# Rezoning Transportation Analysis

Petition Number: 2021-163

**Lakisha Hull**

Date	Description
08-26-21	First Review (LH)

RZ-01

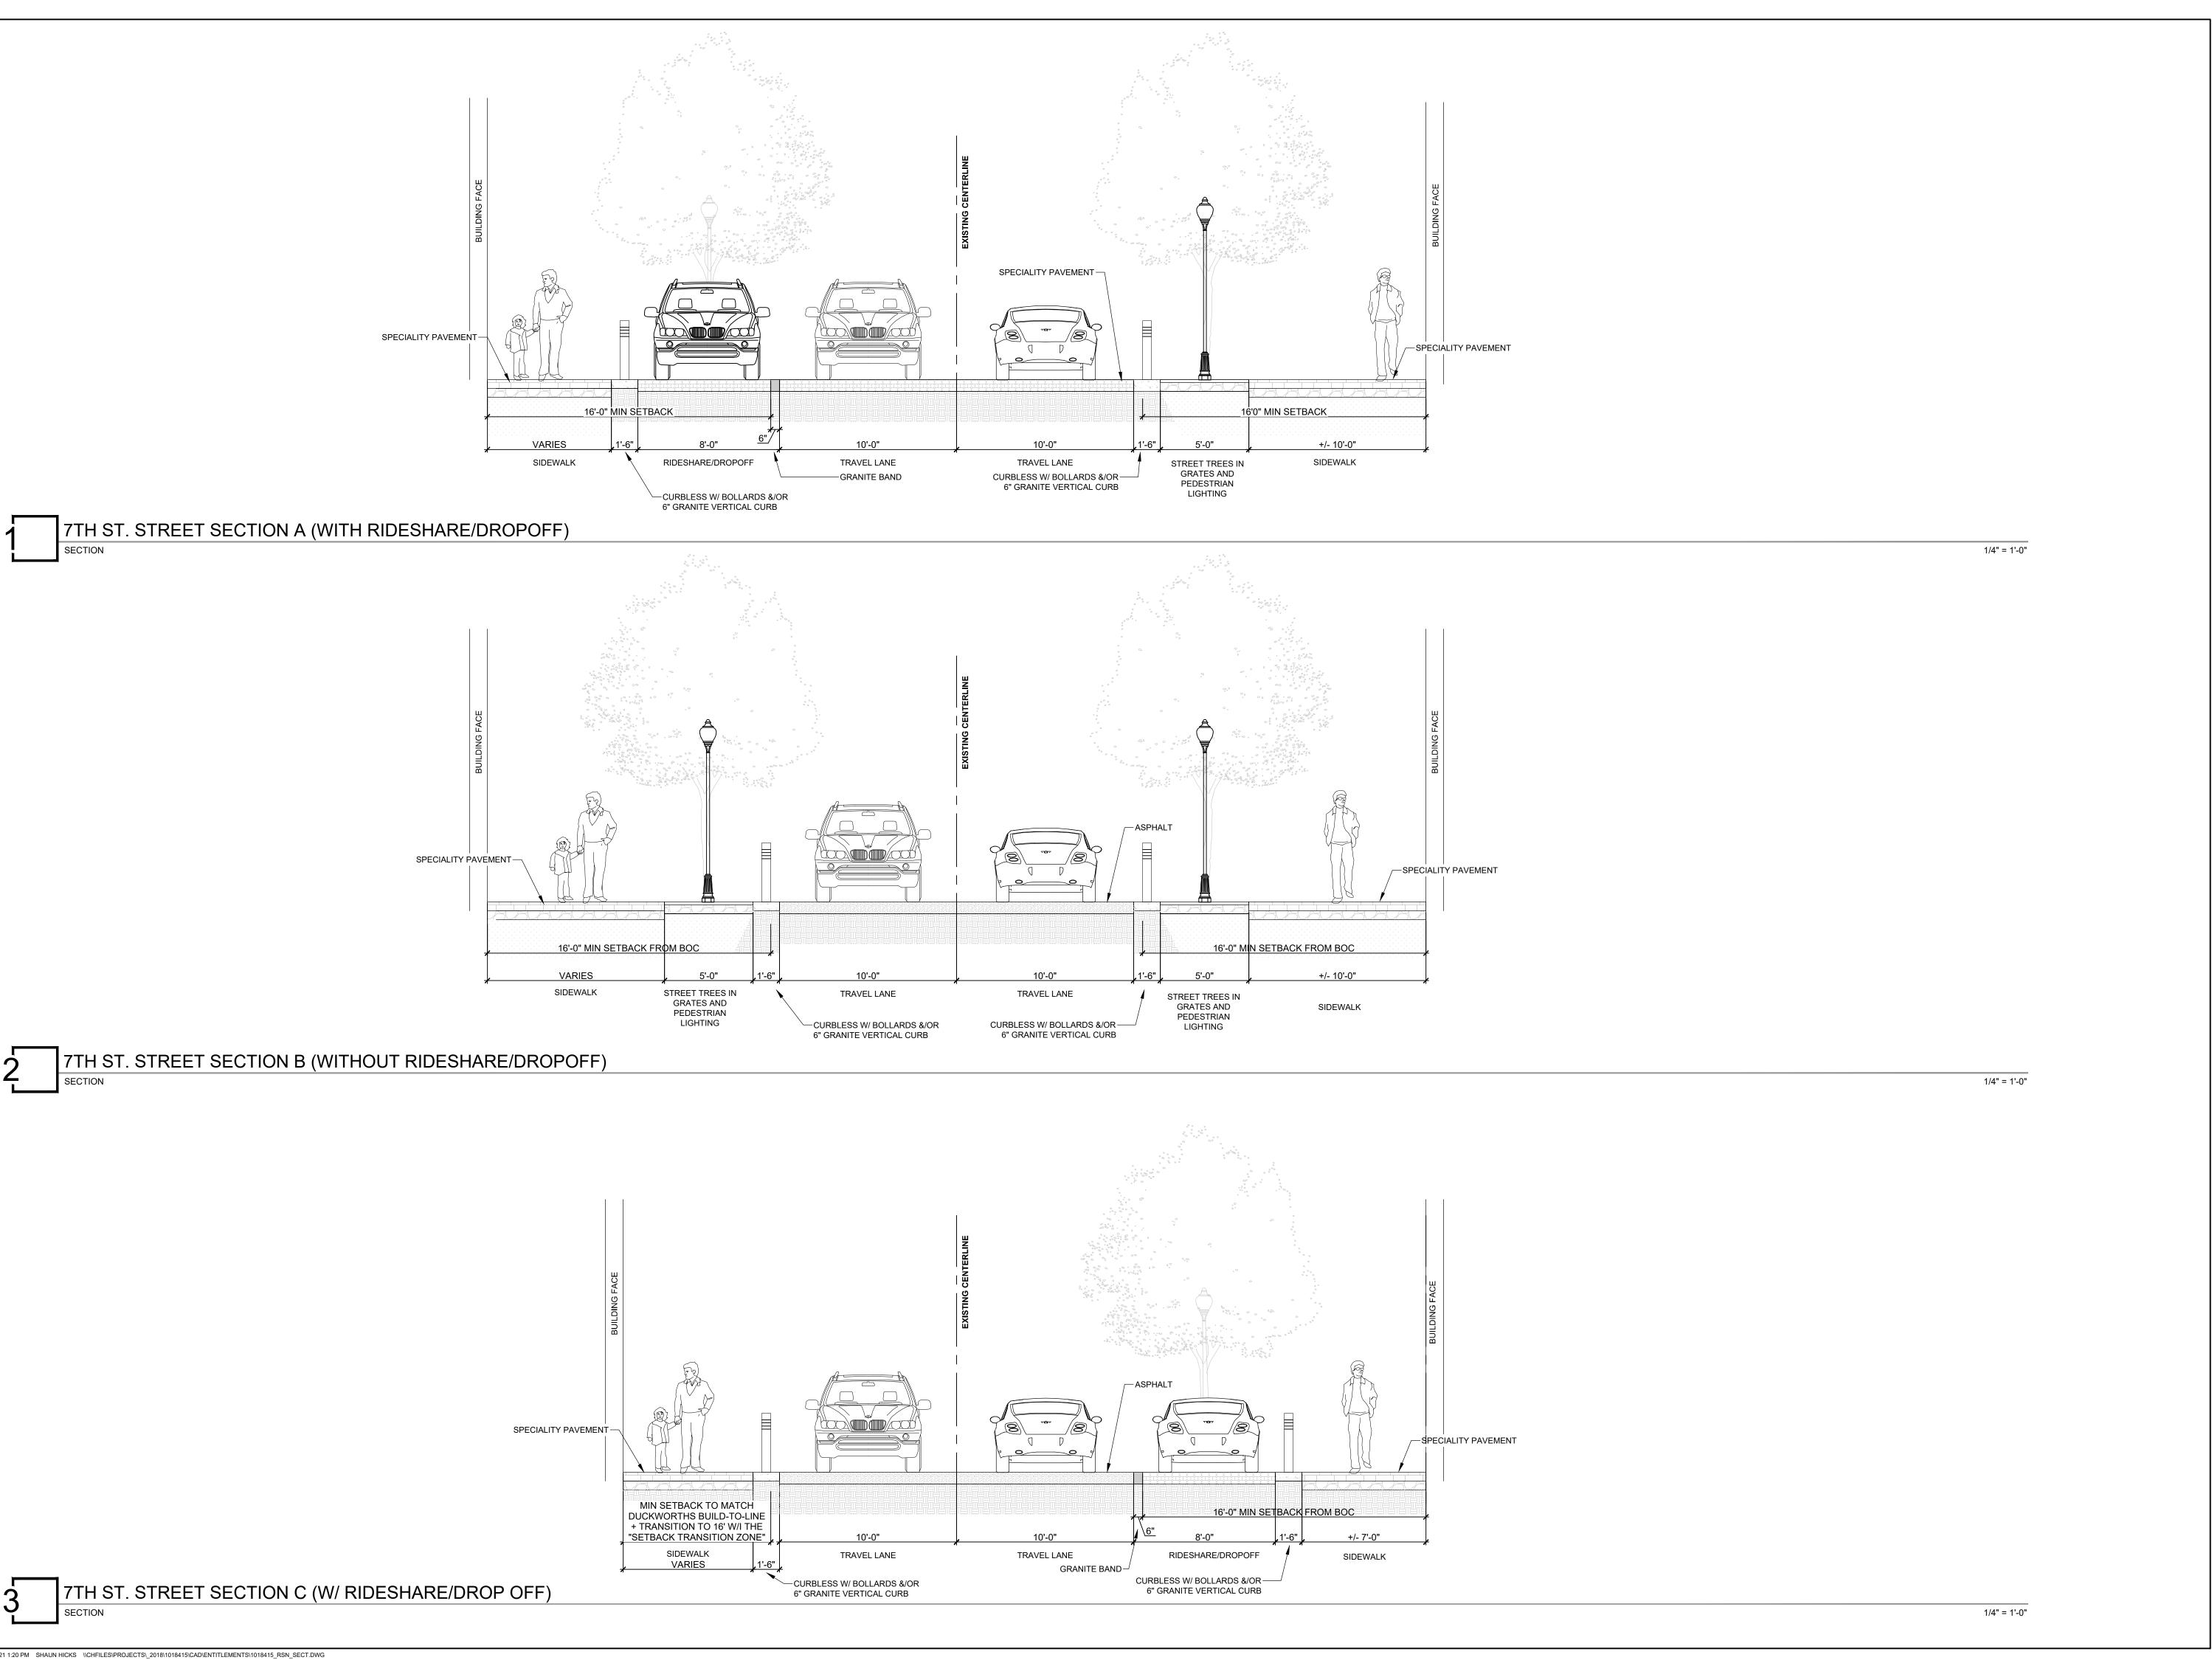
3. **Site Plan (General Comment):**
  - a. Clearly show existing and proposed curb and gutter.
  - b. Show dimensions for 16' setbacks on 6<sup>th</sup> Street and 7<sup>th</sup> Street.
  - c. Clearly show Right of Way Lines on site plans and cross-sections. Reconcile site plans/cross-sections to ensure all building face/footprints do not encroach within the public right-of-way.

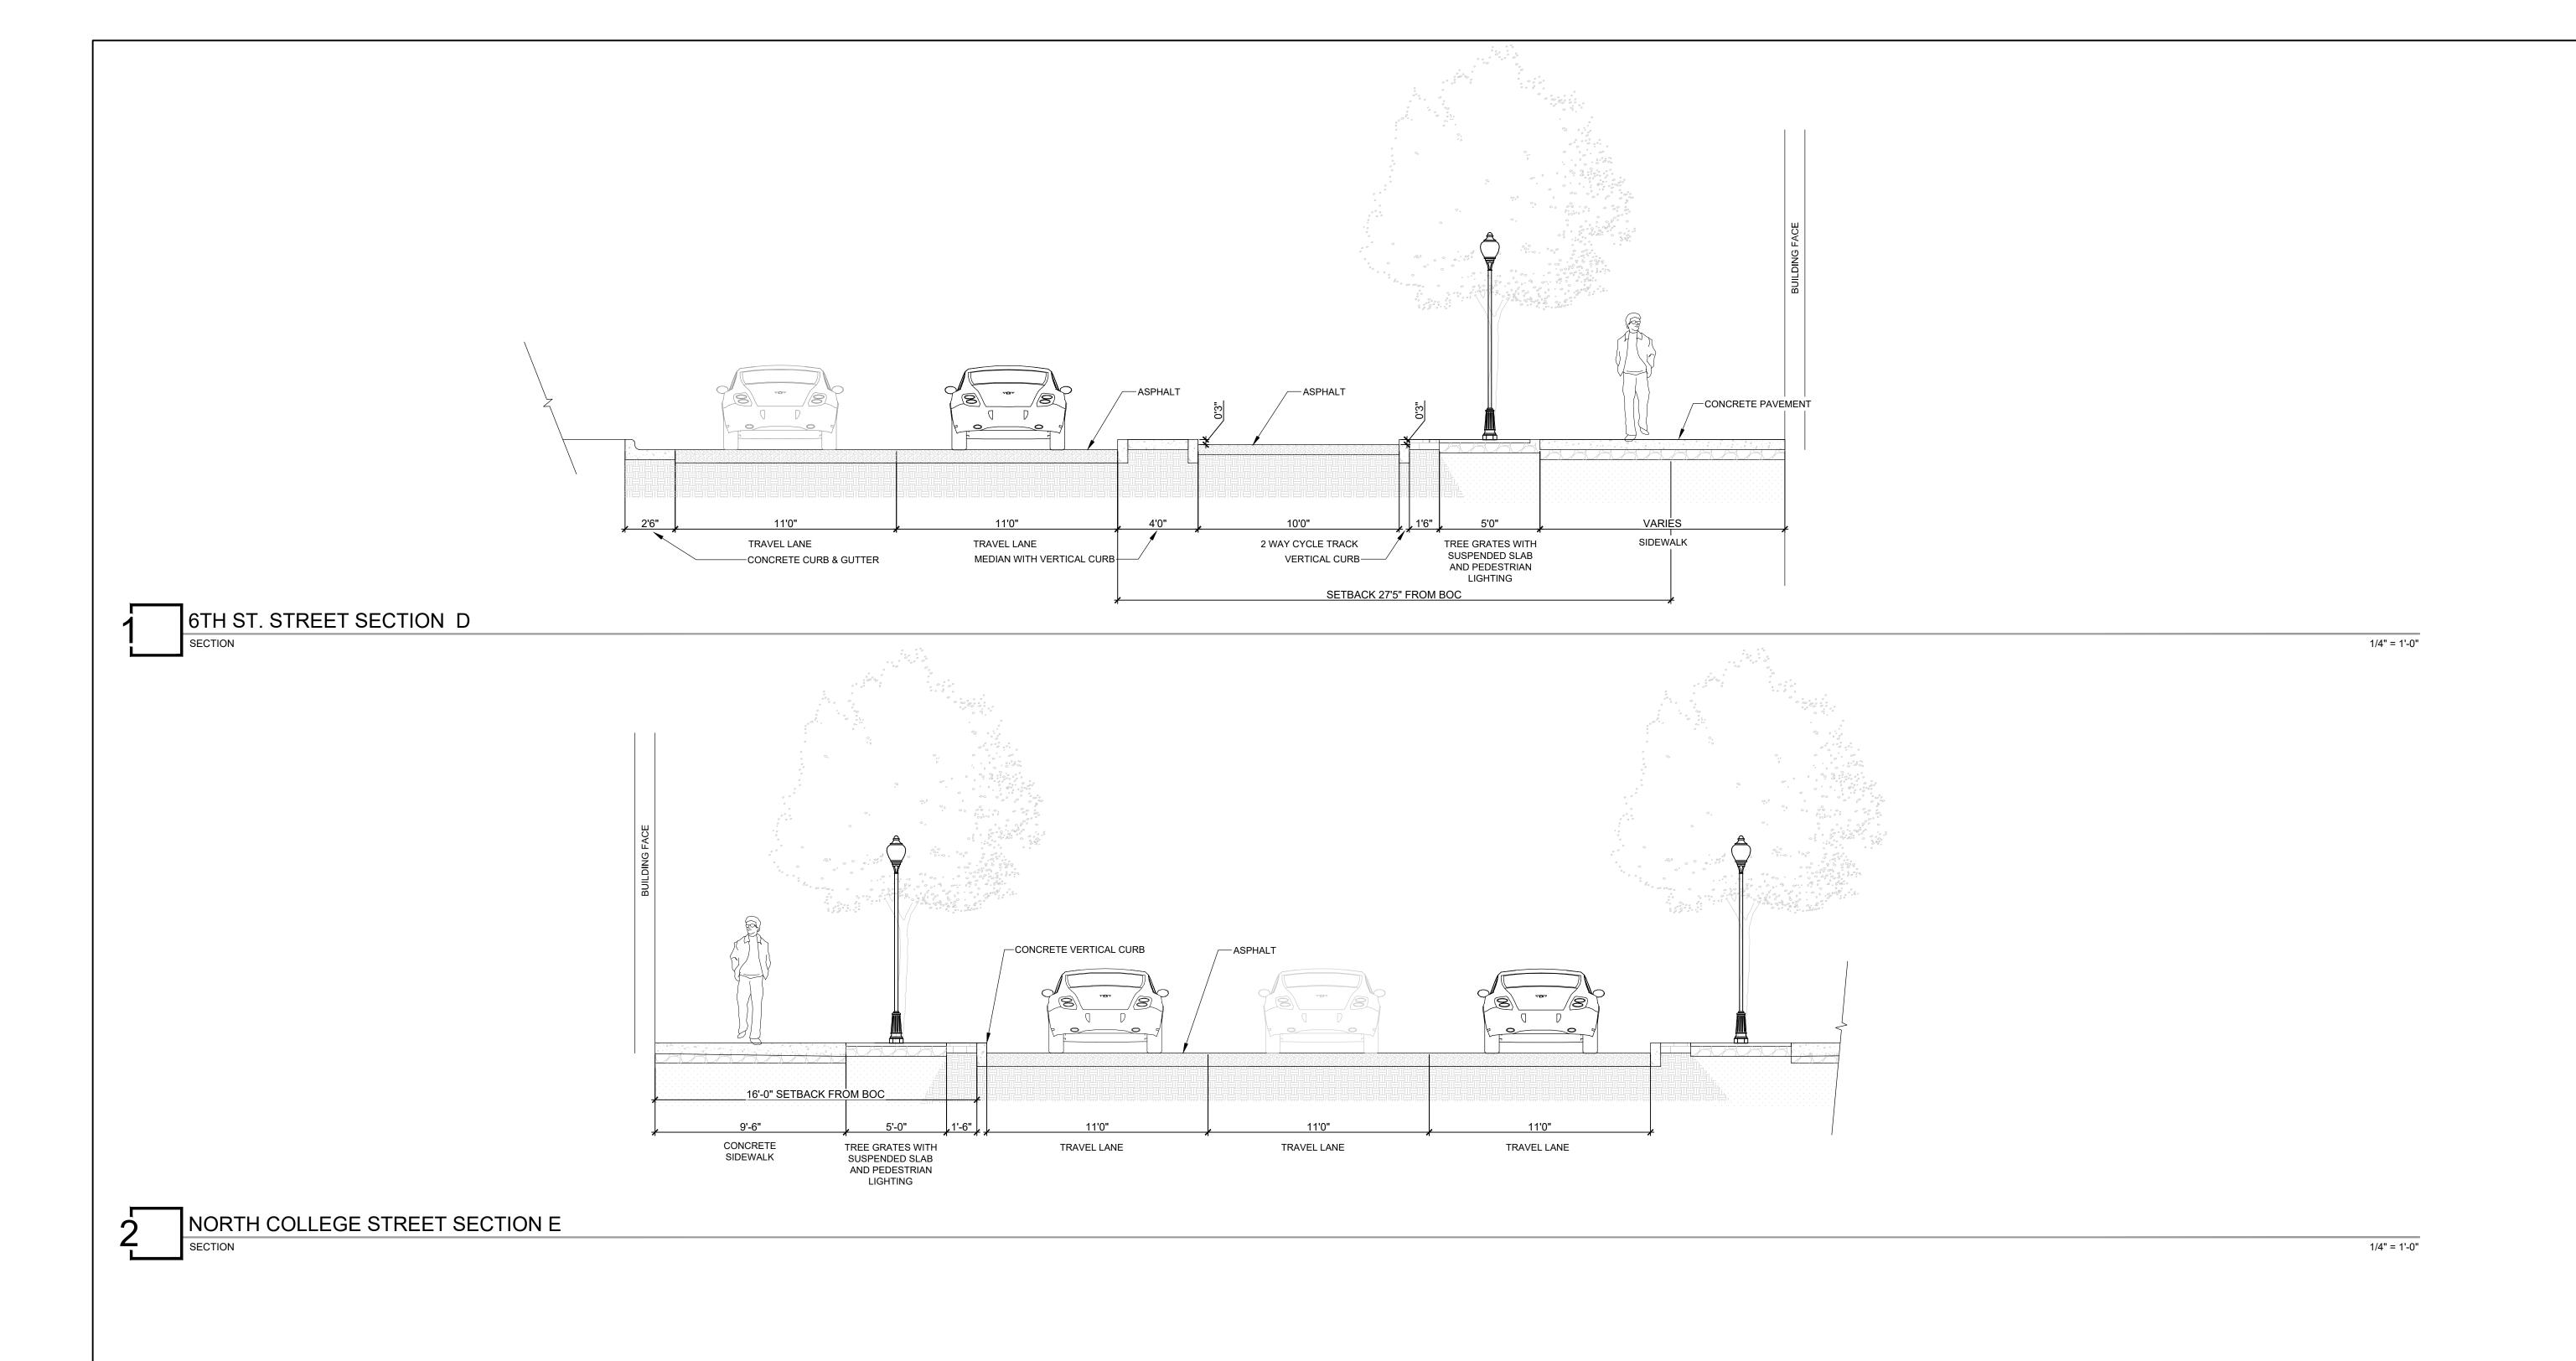
4. **6<sup>th</sup> Street Cross-Section:**
  - a. **New Cross-Section:** Include a second cross-section that shows a consistent 10' cycle track width and 11' travel lanes.

- b. **Right of Way:** Show right of way line on cross-section and ensure building face is outside of right of way.
  - c. **Pedestrian Pathway:** Update site plan and conditional notes to show minimum 12-foot sidewalk width.

- d. **Cycle Track:** Update site plan and conditional notes to show the correct and varied dimensions, as shown below. Add a conditional note that vertical curb and curb and gutter are both acceptable adjacent to the cycle track, but the gutter width cannot be used to account for the 10' cycle track width. Add a conditional note that nonstandard material is allowed in median between cycle track and vehicle travel lanes, but an encroachment permit will be required. Additionally, provide a conditional note that specifies the commitment of constructing the cycle track on 6<sup>th</sup> Street.

- e. **Dimensions:** Adjust dimensions as shown below:
